## DEVELOPMENT HEARING OFFICER

### Planning Comments

**Project Number:** PR-2025-020092

**Project Name:** Lots 1A-1-A, 1A-1-B, 4A-1-A, and 4-A-1-B, Block 3, Volcano Cliffs Unit 26

Figure 1: Aerial of Site and Vicinity.

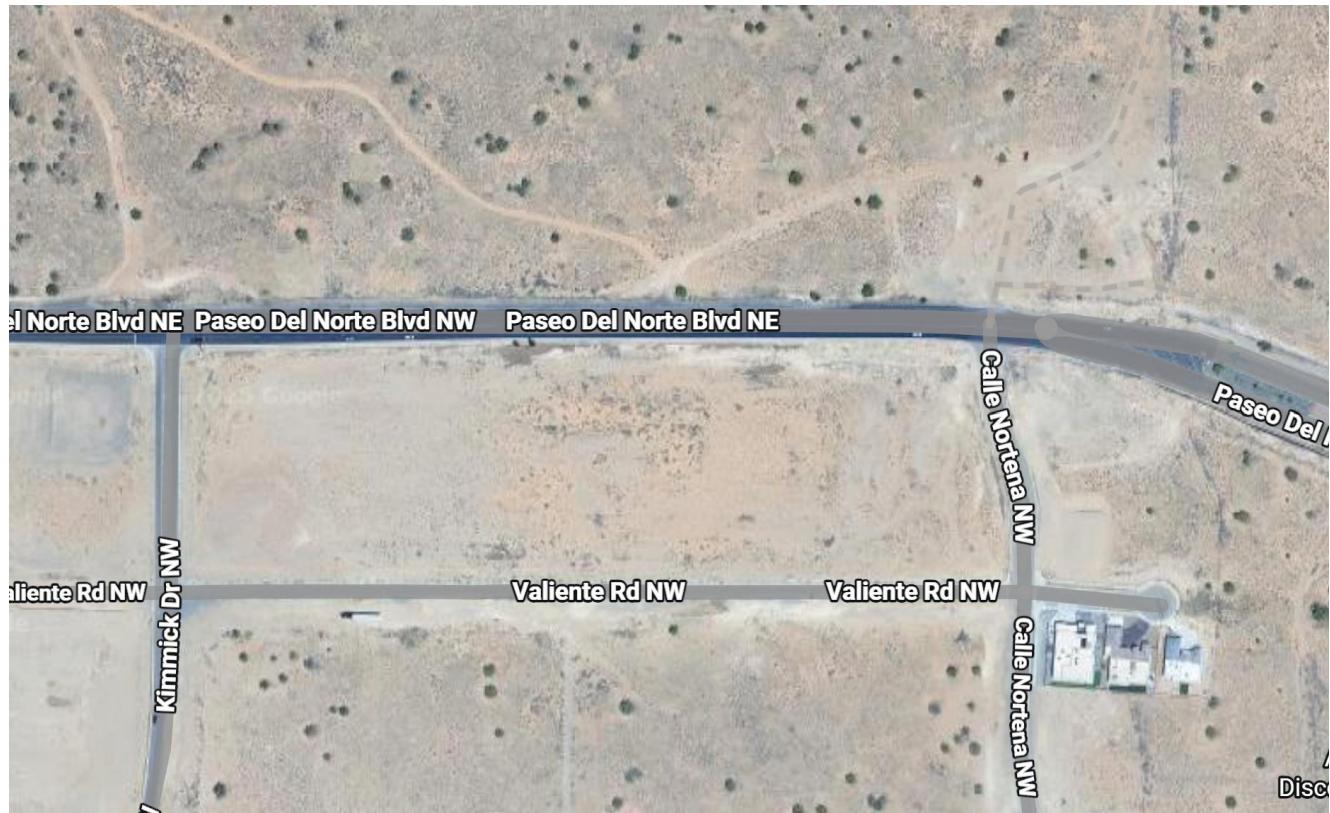
- A Sensitive Lands Analysis was submitted confirming that no sensitive lands per 5-2(C)(2) of the IDO are present on the subject property with the exception of steep slopes per 5-2(C)(2)(h); the IDO defines steep slope as land with 9 percent slope or more, where development is discouraged. The Analysis asserts that an overwhelming majority of the site exhibits slopes below 9 percent, with a small area in the southwestern corner of the subject property slightly exceeding 9 percent.

More details must be provided in the Sensitive Lands Analysis confirming the following:

1. A precise location of the portion of the site exhibiting slopes over 9 percent must be depicted in the Analysis.
2. The slopes over 9 percent must be specified (slope percentage) and labeled in the Analysis.
